Re: Inspection Items

104 Sherman Pines Dr, Fuquay-Varina, NC 27526 - Harnett Co.
Project #: 23091

Arrow Design, PLLC was contacted on 8/28/23 and was requested to review several items noted during inspection by the county building official. Below is a summary of the items Arrow Design, PLLC evaluated. All direction references are based on viewing the structure from the rear of the home.

TITLE:
**HOBBS COVERED DECK
(OPTION 3)**

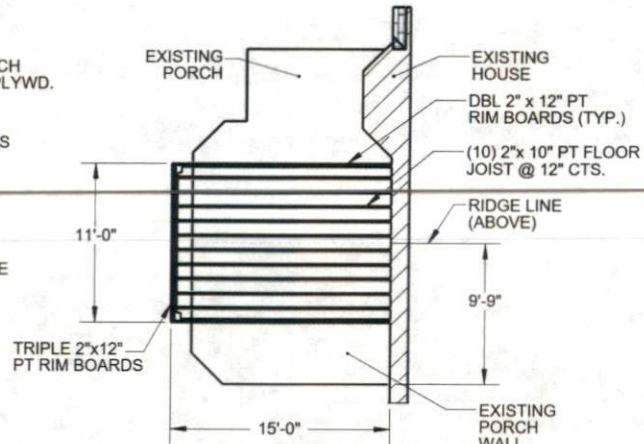
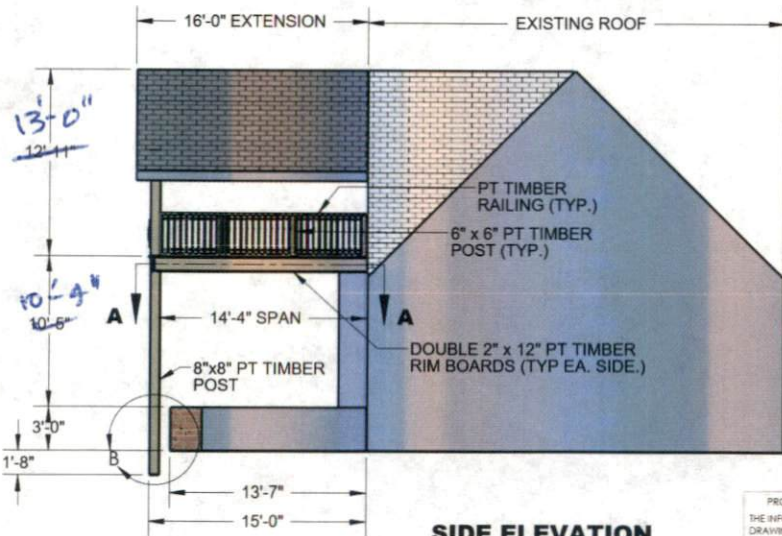
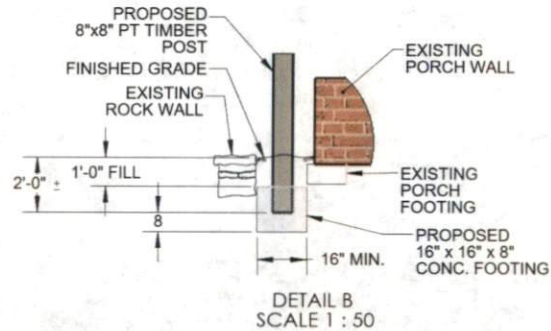
1. It was noted that the exterior 2-ply deck band of the deck was not attached to the deck ledger properly. The ledger board stopped short of the final ply of the deck band and the band was just nailed to the ledger.
 - Refer to Figure 1 at the end of this report for the repair.
2. The 3-ply gable end rafters were only connected to the top of the 8x8 post/porch header with nails.
 - Attach the rafter to the post/header using (4)SST SDWC15600 truss screws.
3. The porch header was attached to the post using (2)1/2" thru bolts.
 - This attachment is an adequate alternative to the previous report connection specifications. No repair is required.
